THE COTTAGES AT MESA RIDGE
GOODWIN KNIGHT
EL PASO COUNTY, COLORADO

PUD DEVELOPMENT PLAN PUD Landscape Plan
~~PRELIMINARY~~ LANDSCAPE PLAN

Landscape Plan drawings_V1 redlines.pdf Markup Summary

GOODWIN KNIGHT logo, PUD/ PRELIMINARY PLAN, LANDSCAPE COVER SHEET, SHEET L.01, 1

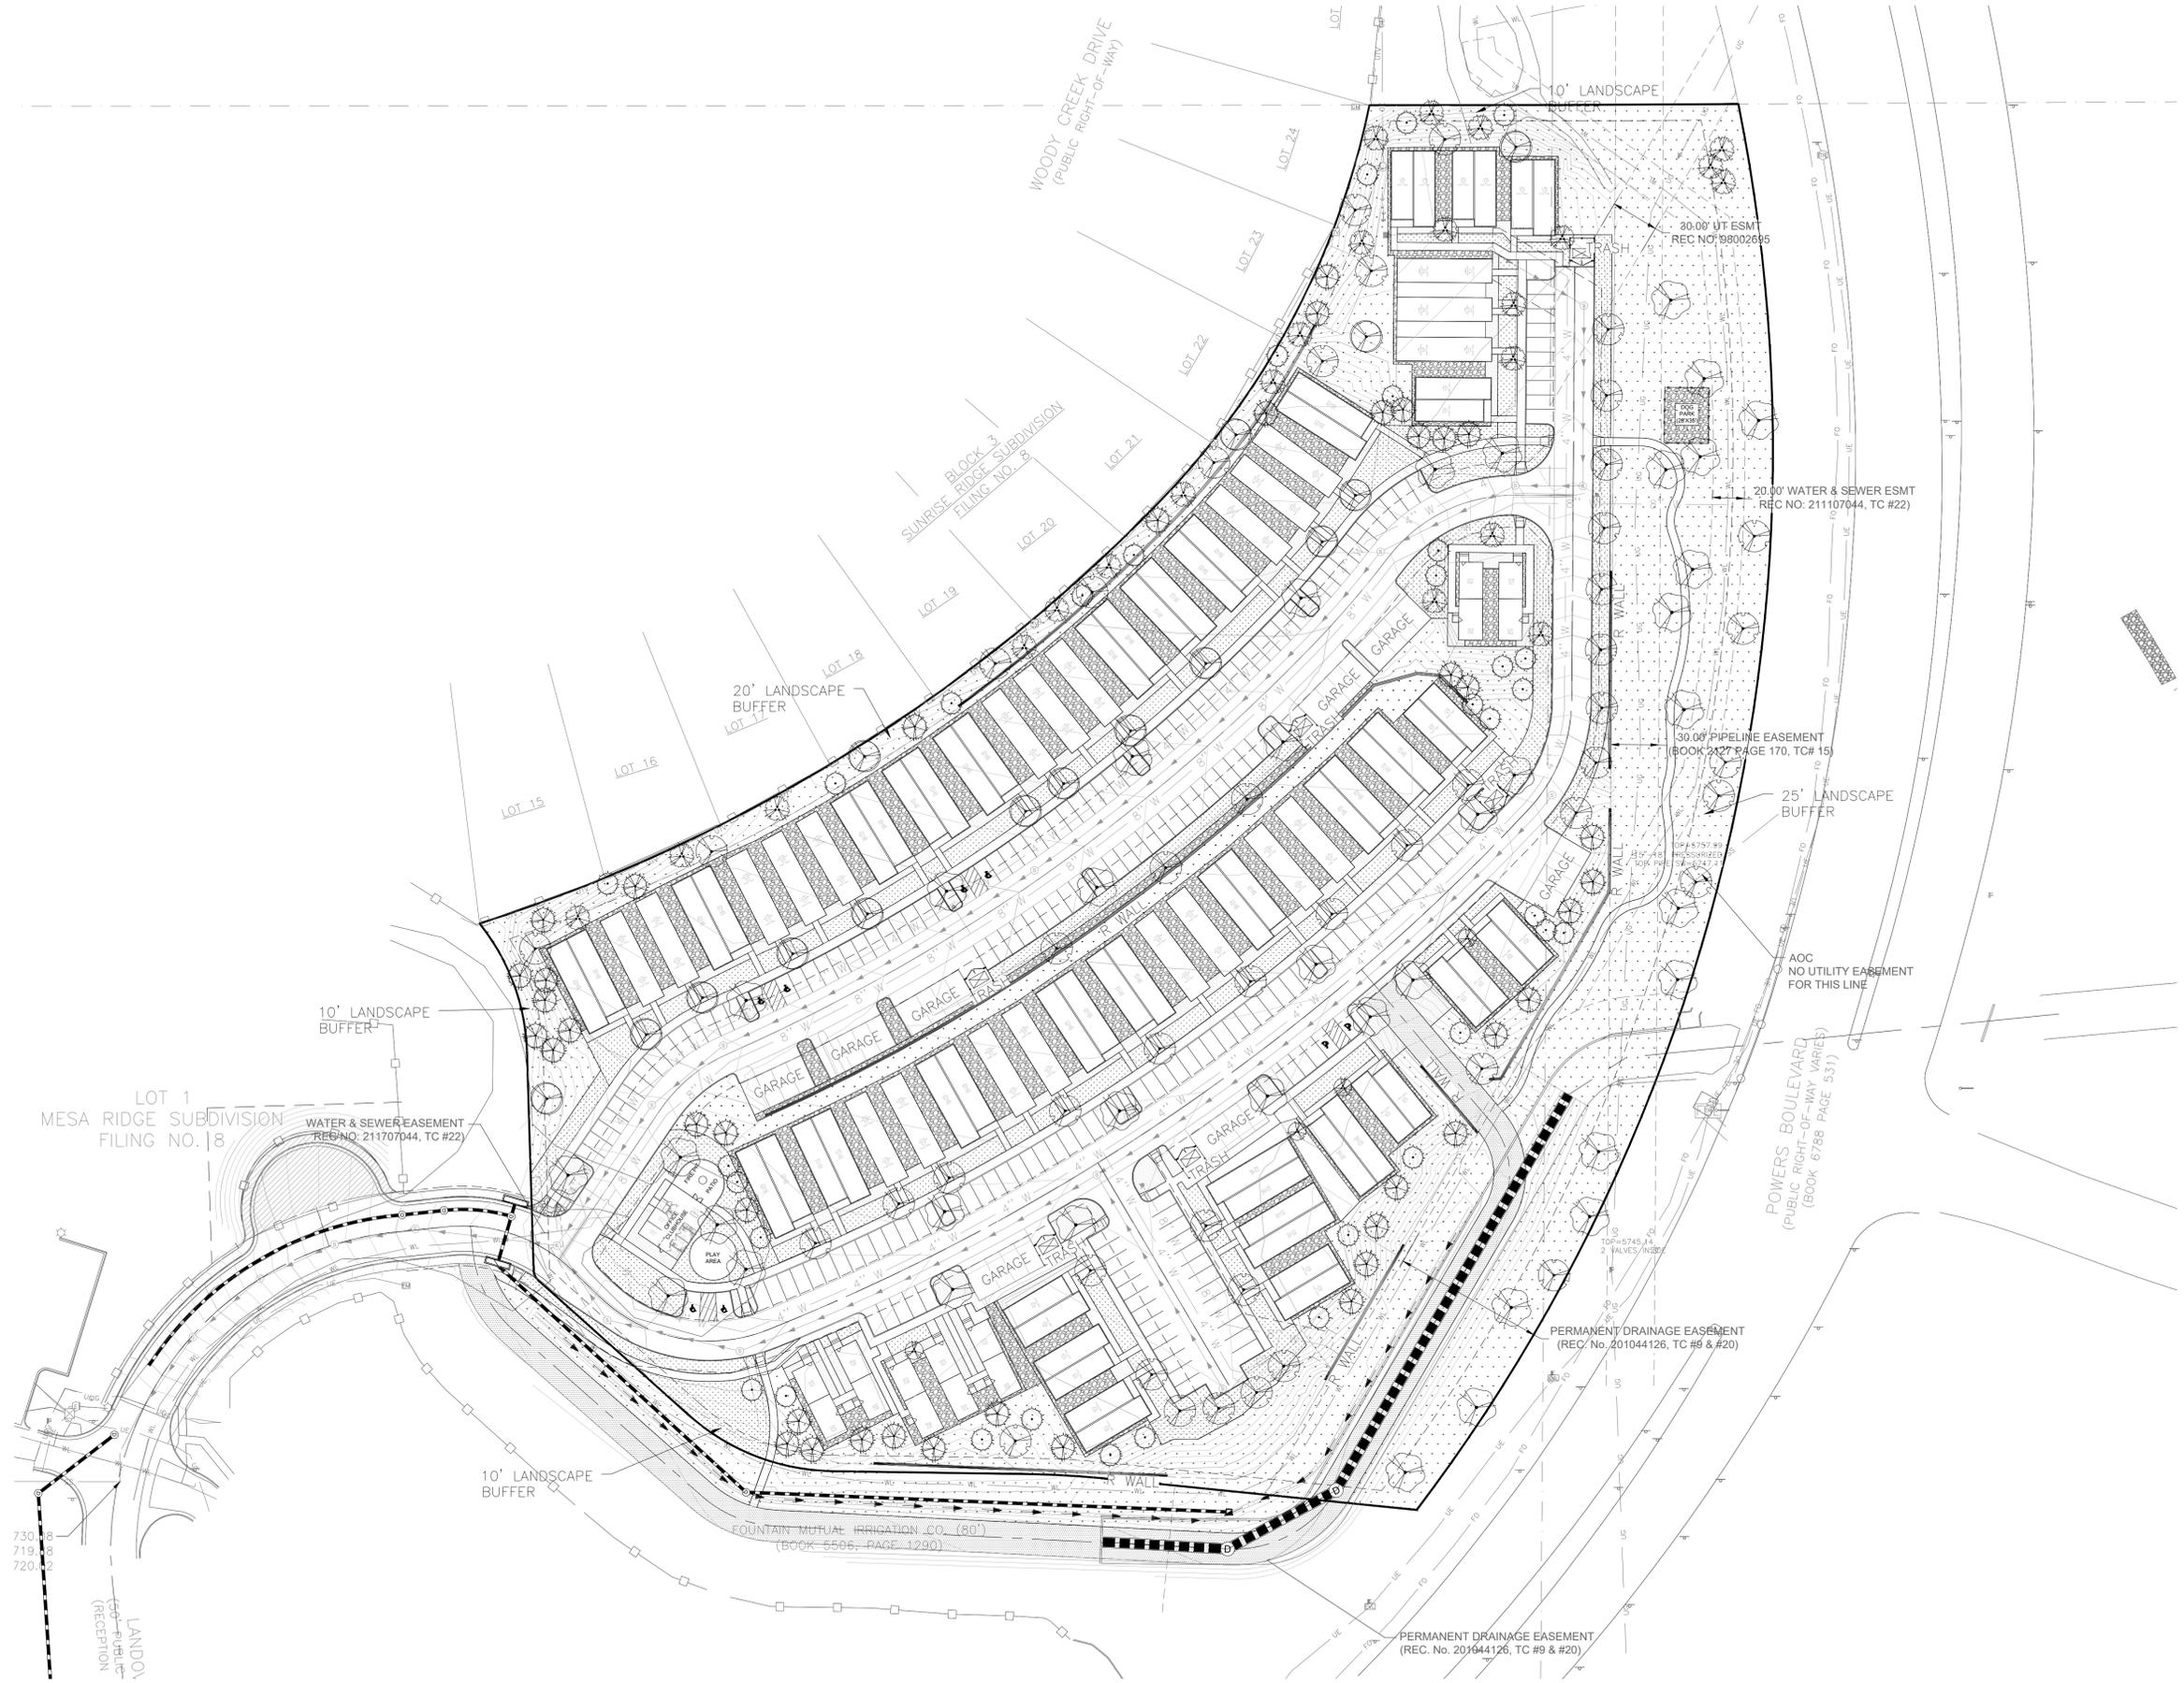
Quantities of each plant

planting details; fencing details,

staff does not require irrigation plans just a statement; this is the PUD so the landscape plan is final

i thought the units were not to be sold? its all in a lot

delete note 6

County is public ROW owner but will not maintain landscape

delete note County is not accepting any internal roads, walks, or improvements

notes 10, 1 and 2 are basically same note

County does not review irrigation plans

provide the detail schematics

no we are County and we do not have forester

symbols for each tree species see above example

what is the evergreen shrub symbol? deciduous shrub symbol?

grass and perennial symol or Cloud with Key on plan

CA -20 count
